DECISION DELEGATED TO DEVELOPMENT MANAGER

Application No: H14-0948-20 **Applicant:** Mr M Yould
Proposal: Erection of Dwelling - Amendments to approval H14-0626-18. (retrospective)
Location: Cecil Francis Farmyard Blue Gowt Drove Spalding
Terminal Date: 17th December 2020

Site Block Plan

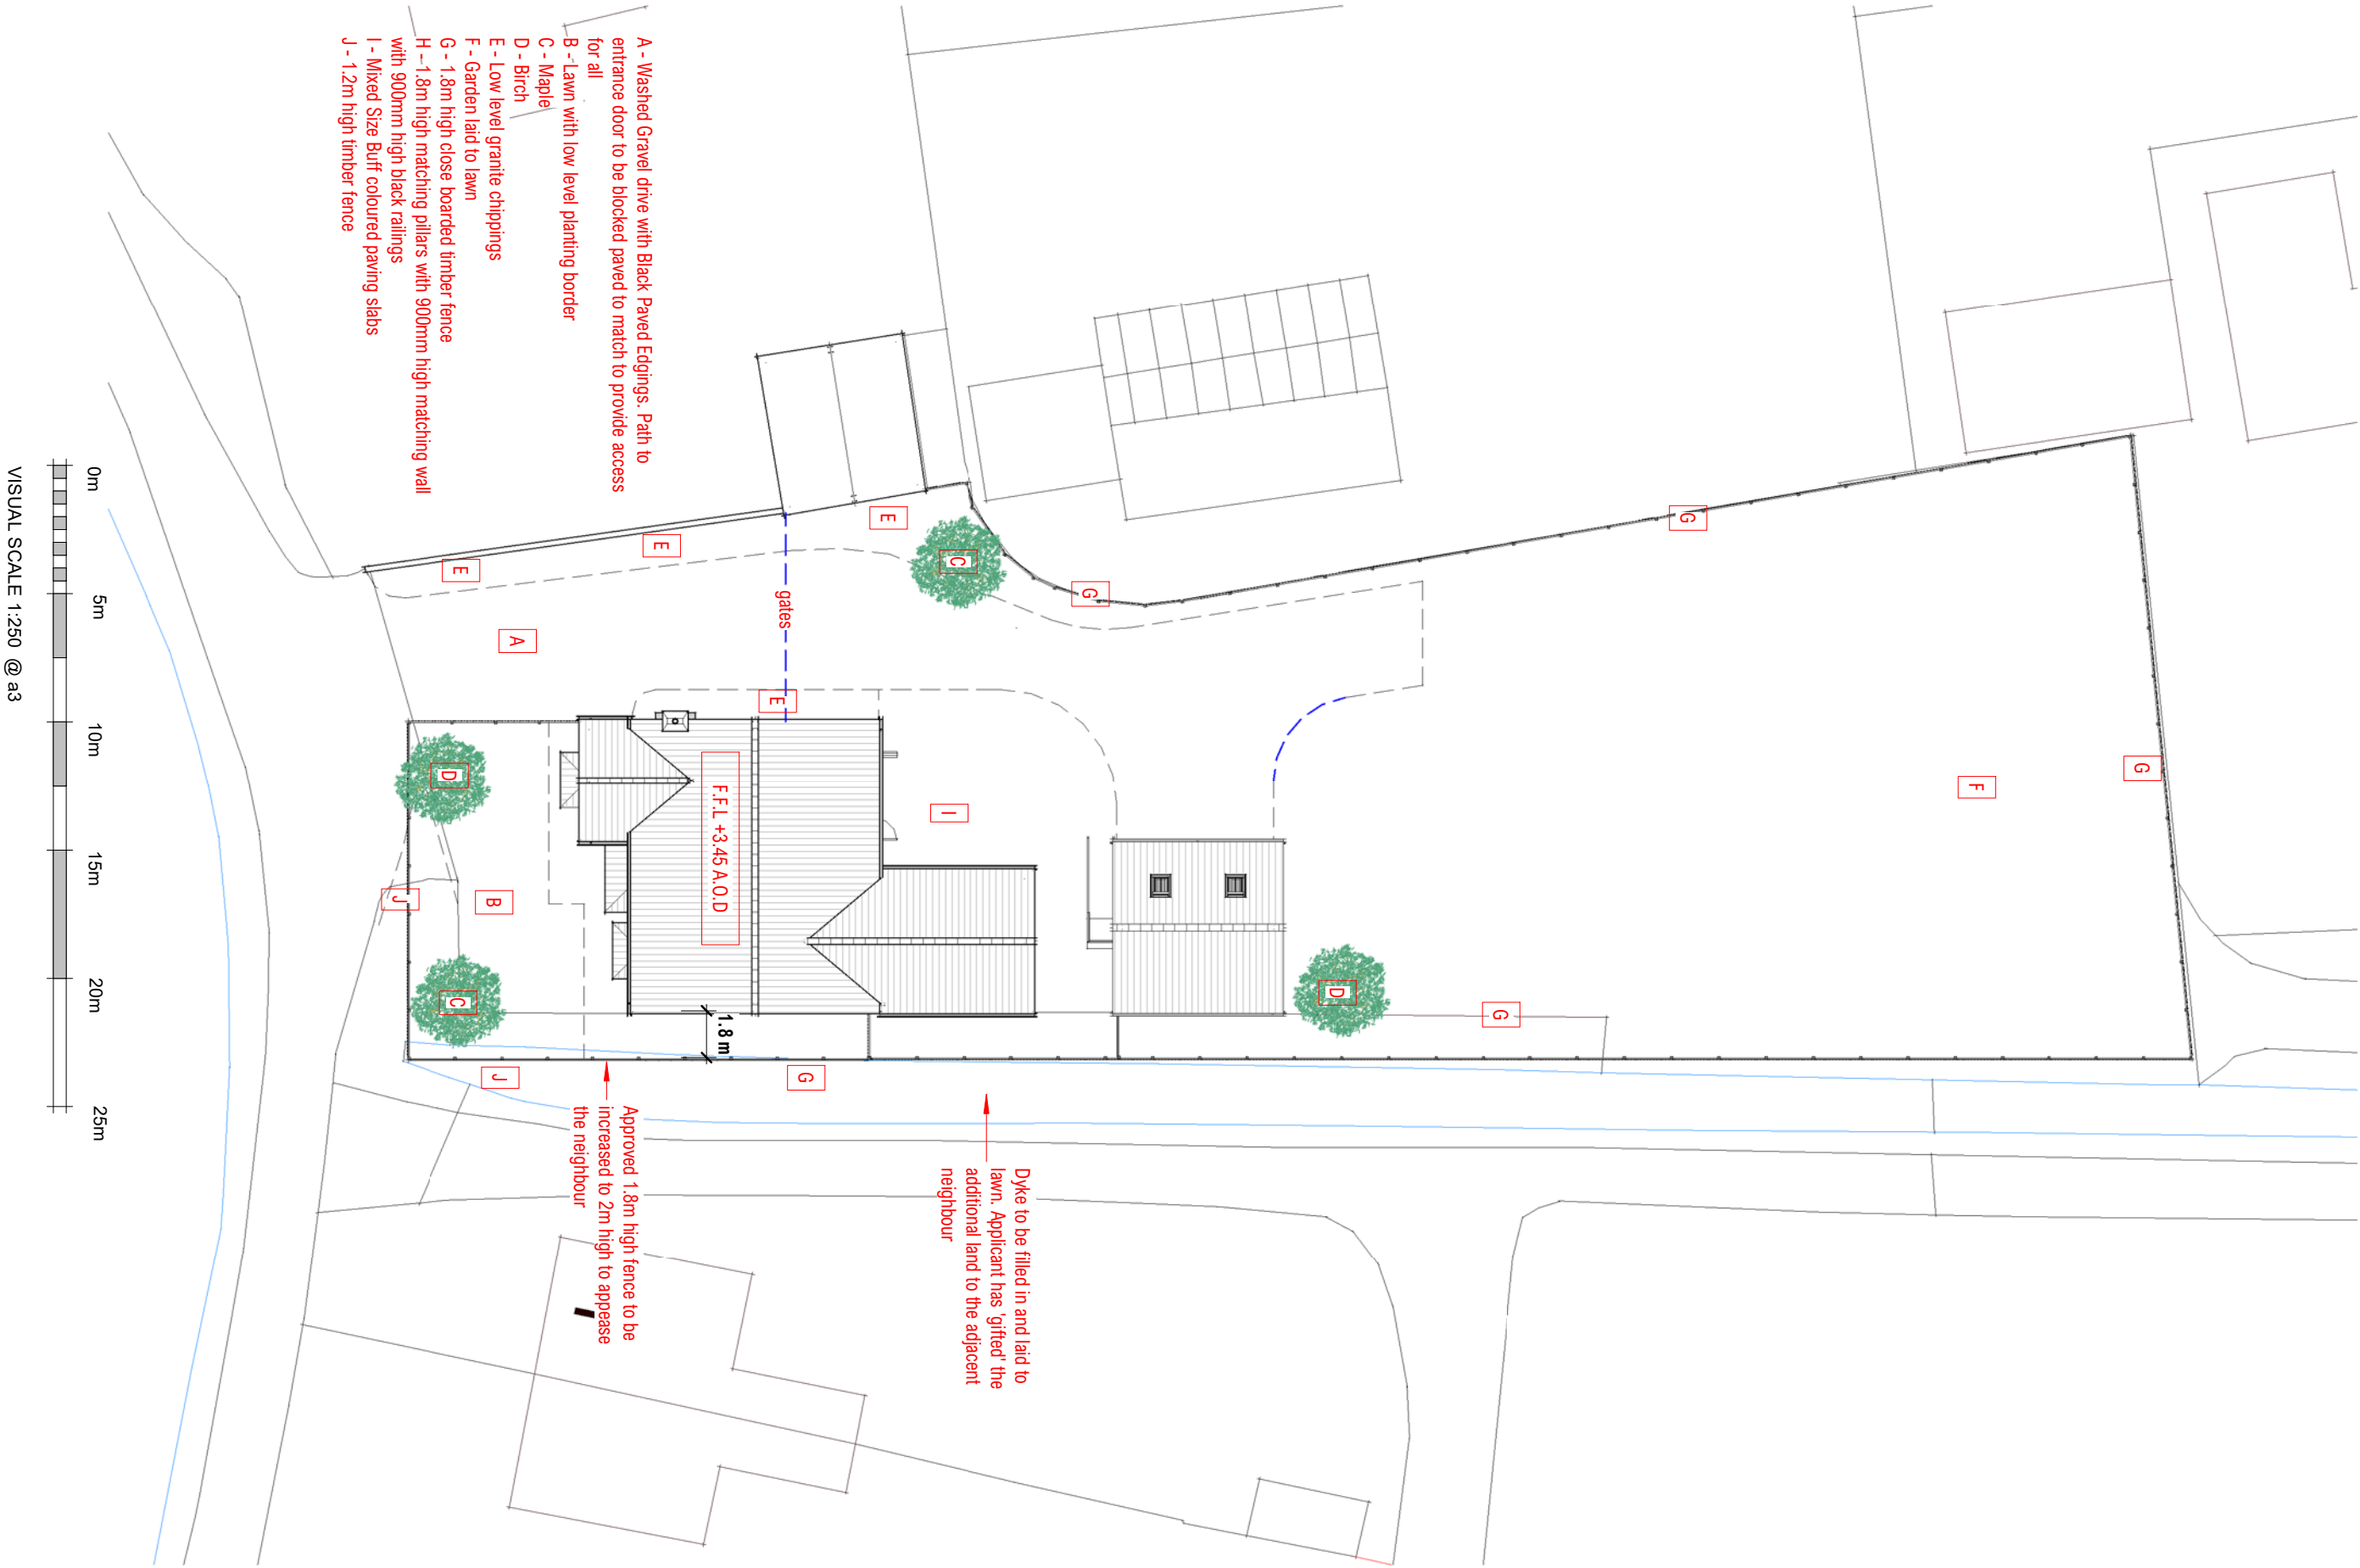
The approved plans showed a 1.8m high fence along the eastern boundary, which has been installed, however the applicant is proposing to increase the height of this fencing to 2m in height. This is in response to concerns being raised by with regard to overlooking. It was noted on the site visit that the conservatory to the rear of the neighbouring property is visible from the kitchen window. An increase of 20cm should be sufficient to mitigate this overlooking aspect.

During the course of development the watercourse along the eastern boundary has been filled in and the fencing installed further across than previously approved. The Welland and Deepings IDB have been consulted on the application and, although the dykefill was unconsented, are content that the present application can be approved.

Proposed Grd Floor Layout

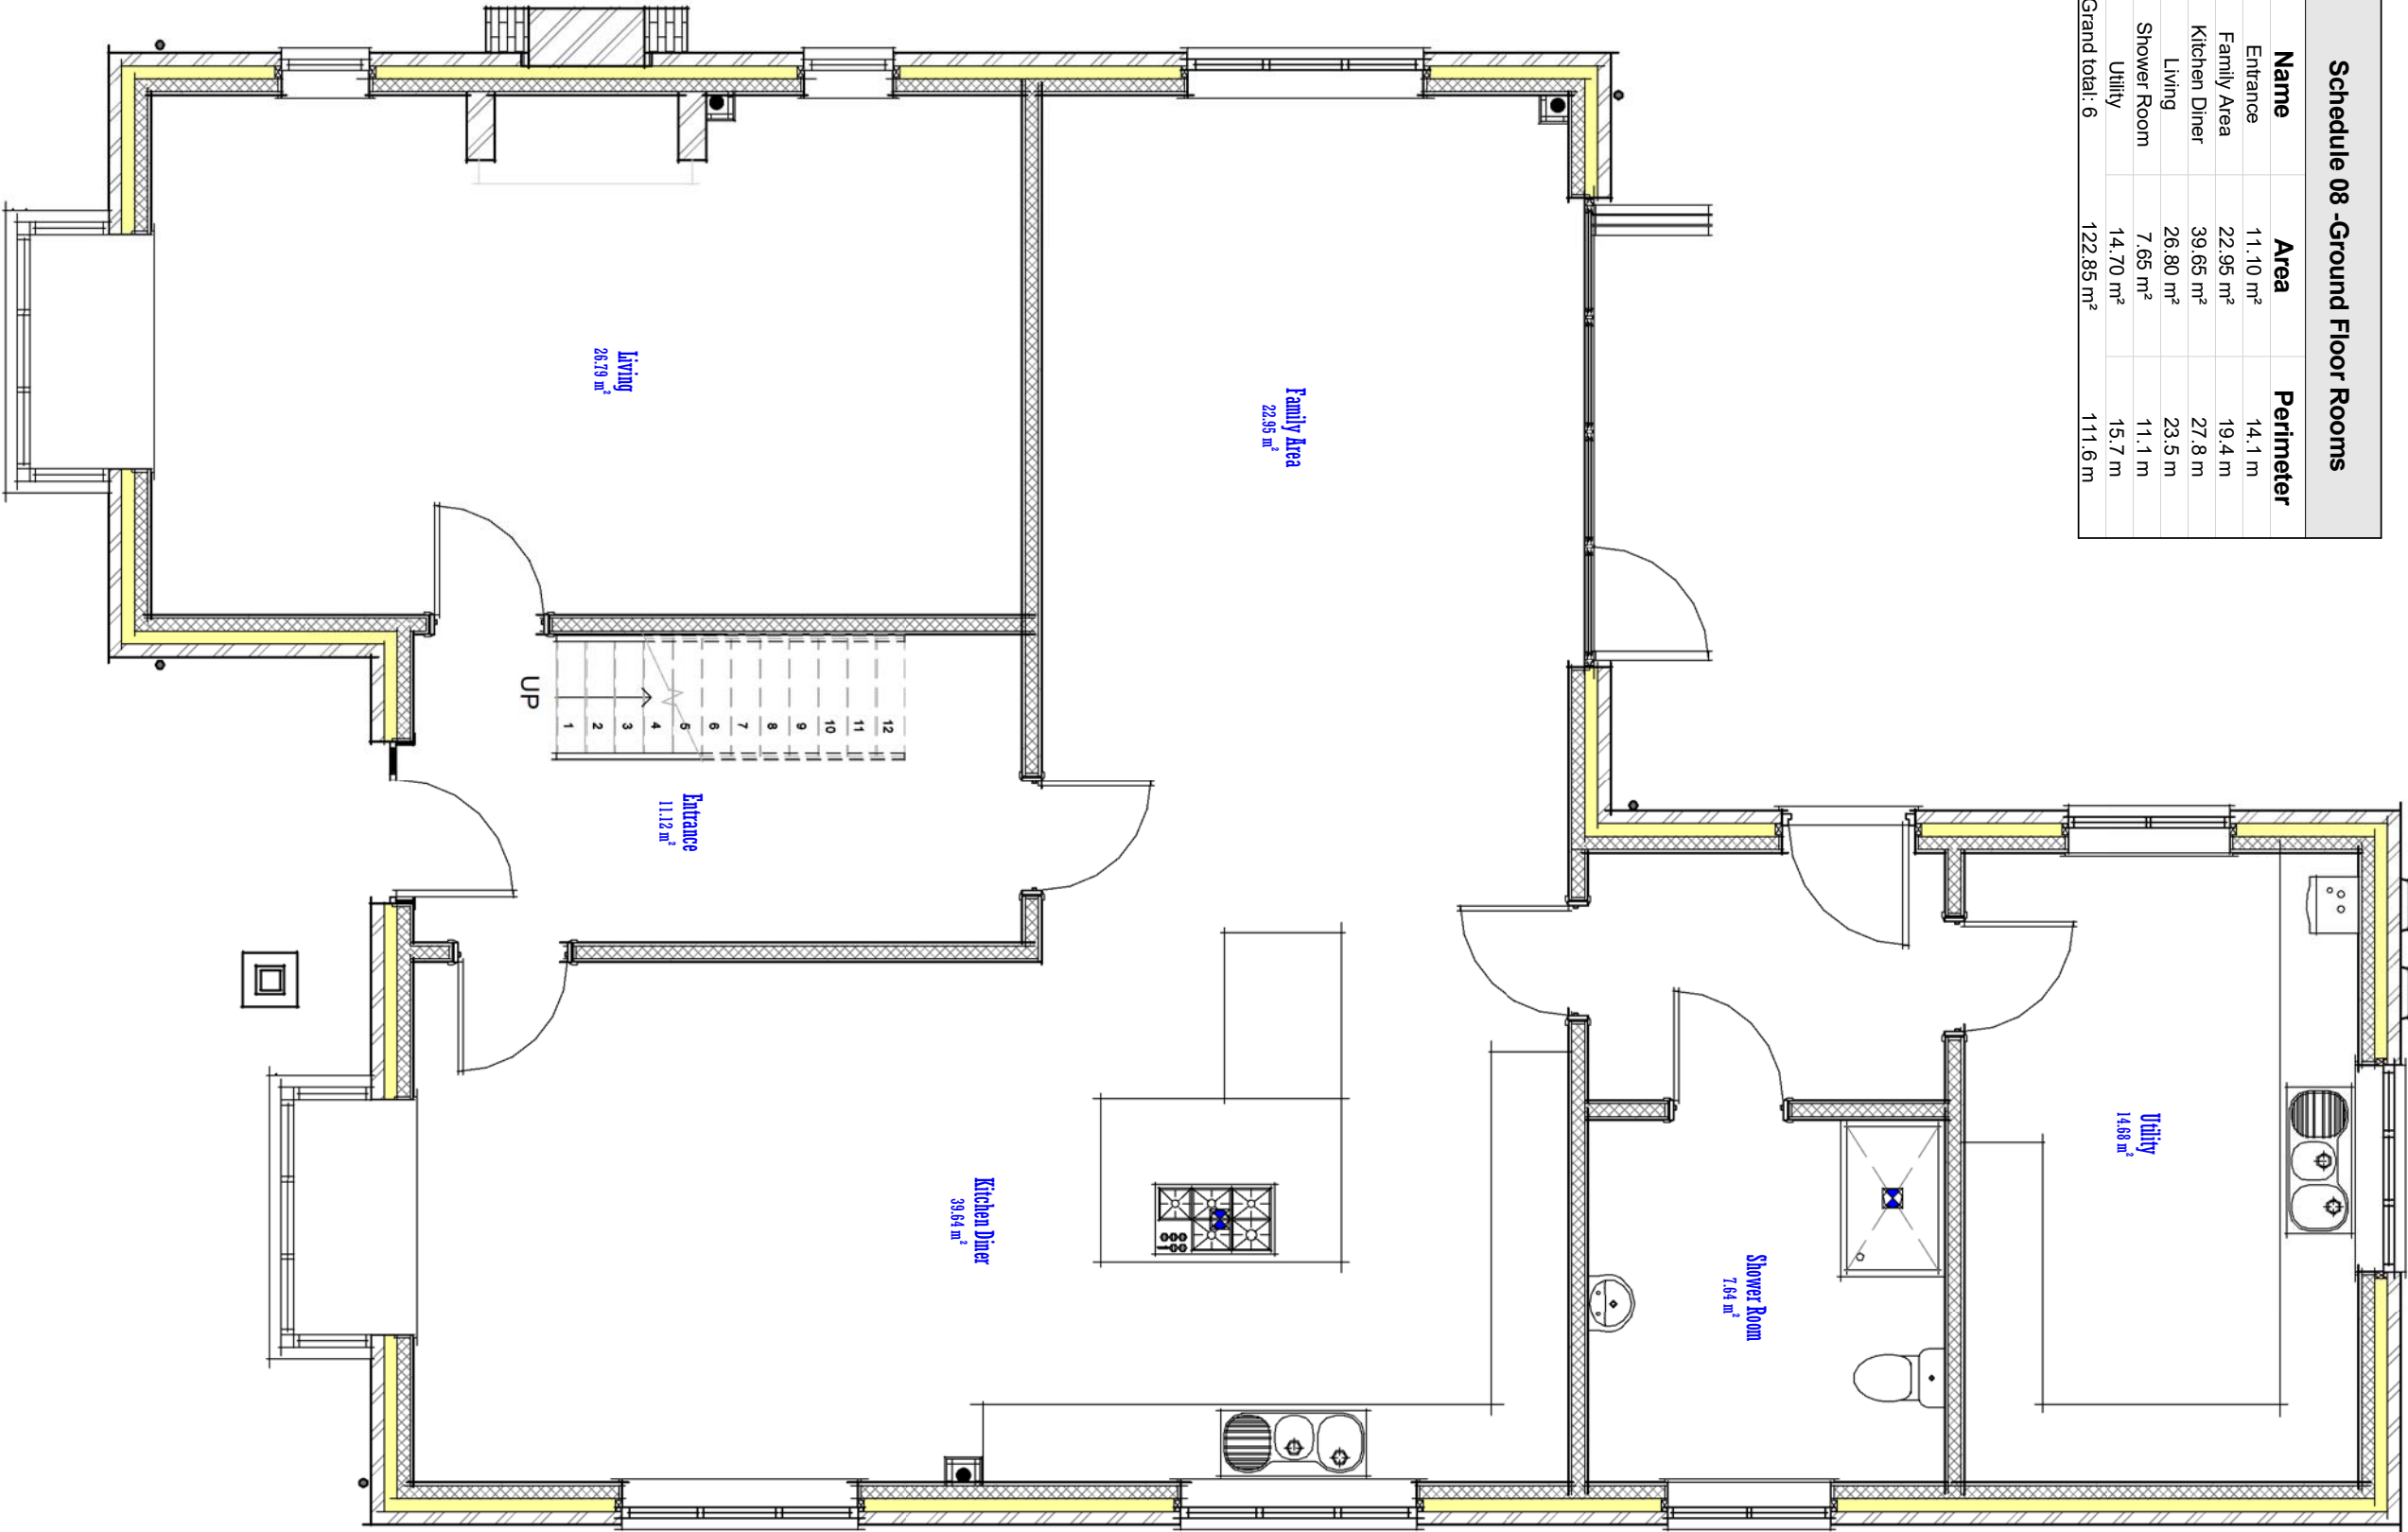
- Roof height increased approx. 100mm
- Bay windows to front elevation altered from canted to boxed and canopy reduced in width
- Soldier brick course added to bedroom 4 and landing windows
- Window and door positions to utility room swapped
- Watercourse along the eastern boundary has been filled in and the fencing installed further across than approved
- Granite chippings rather than bark chippings either side of drive
- 1.2m high timber fence to front of dwelling in place of brick wall/pillars and railings
- Gates installed to side of dwelling
